Rezoning Transportation Analysis

Petition Number: #2021-256

Date	Description
04-12-2022	First Review (AO)
08-22-2022	Second Review (AO)
01-25-2023	Third Review (TM)
03-22-2023	Fourth Review (DR)

RZ-1

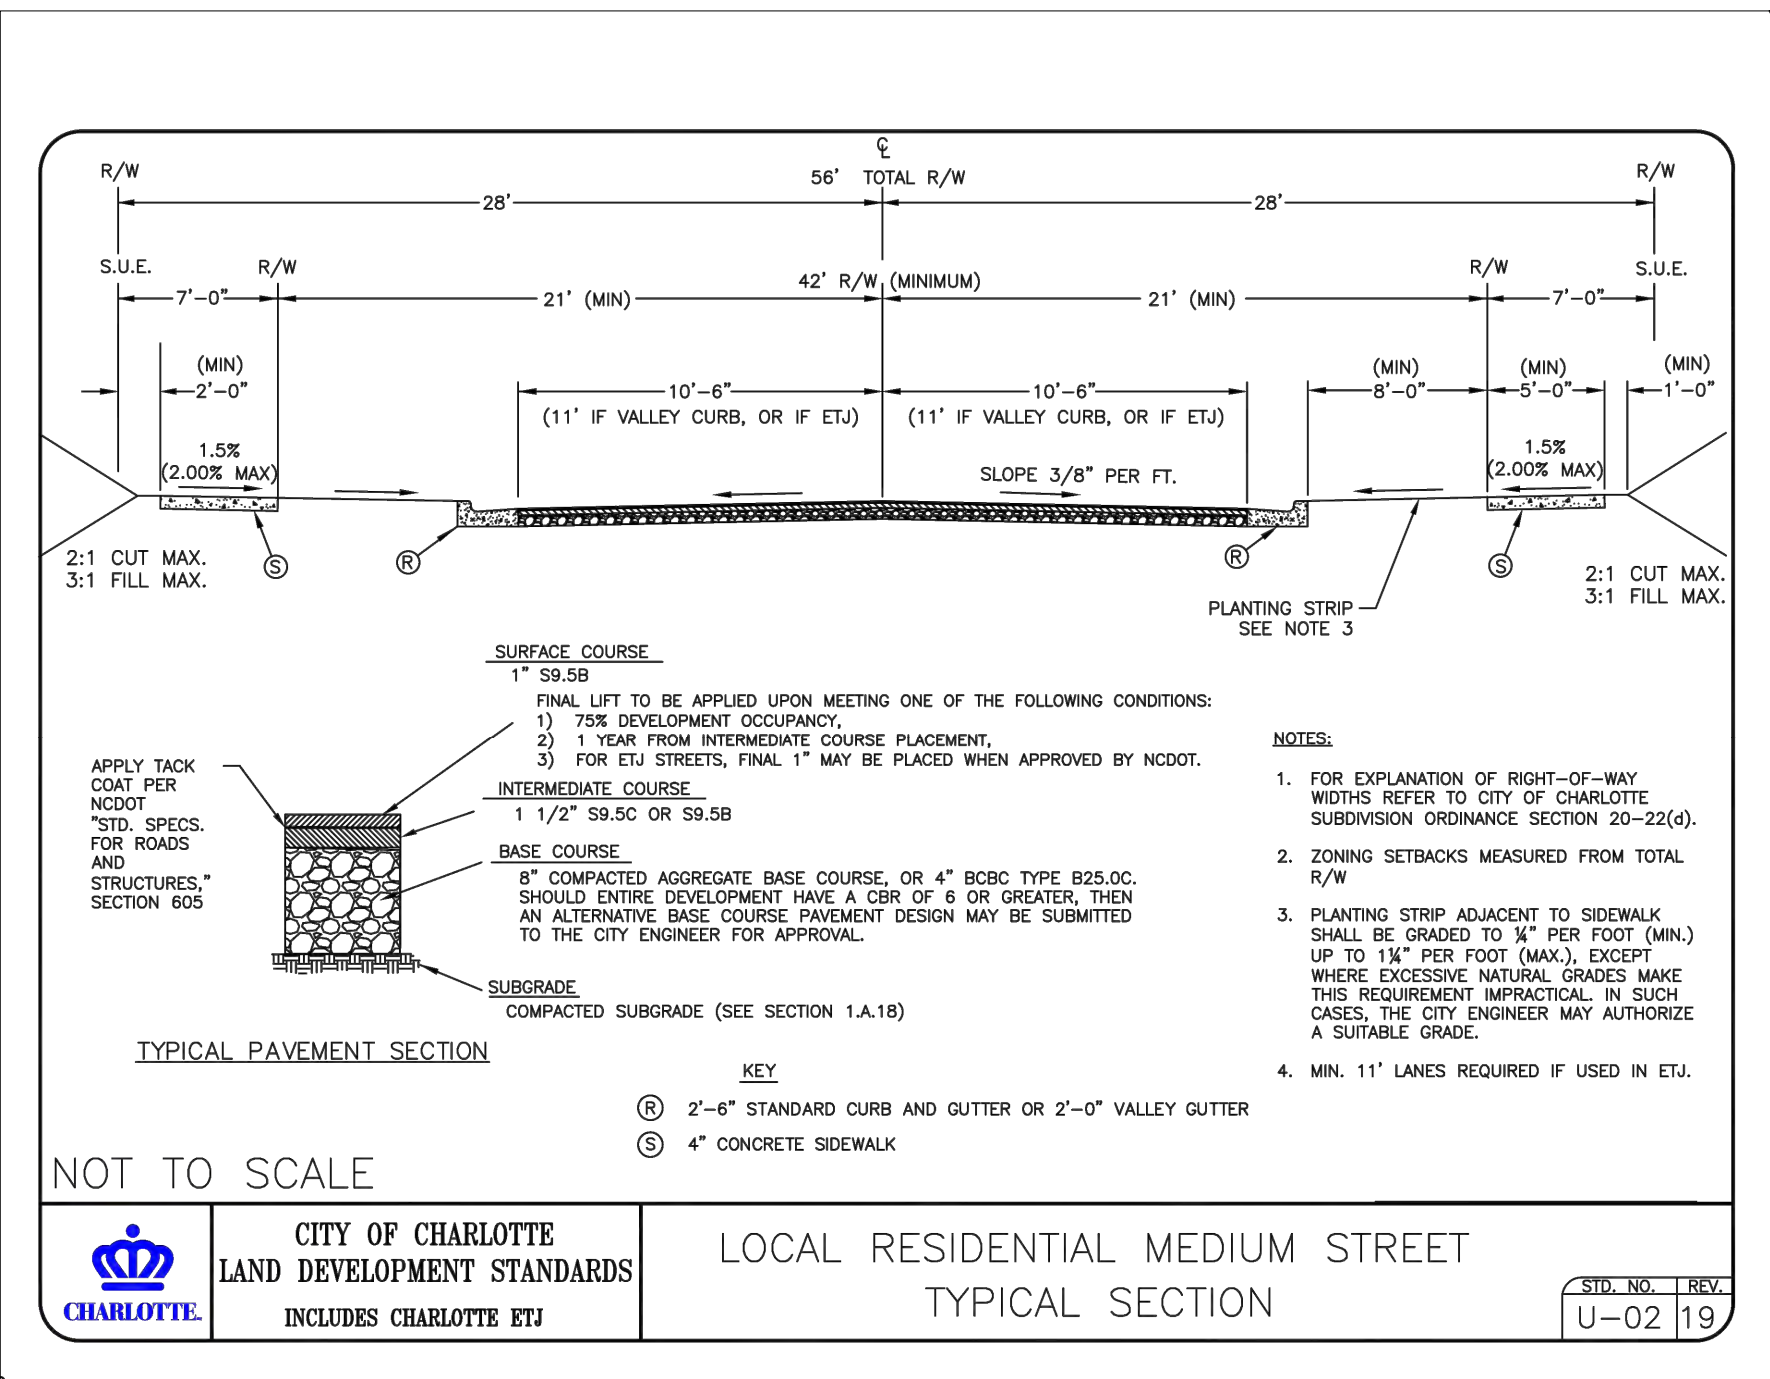
Clarifying Comment 3-22-23: Update conditional transportation notes to include the required transportation improvements from the approved TIS.
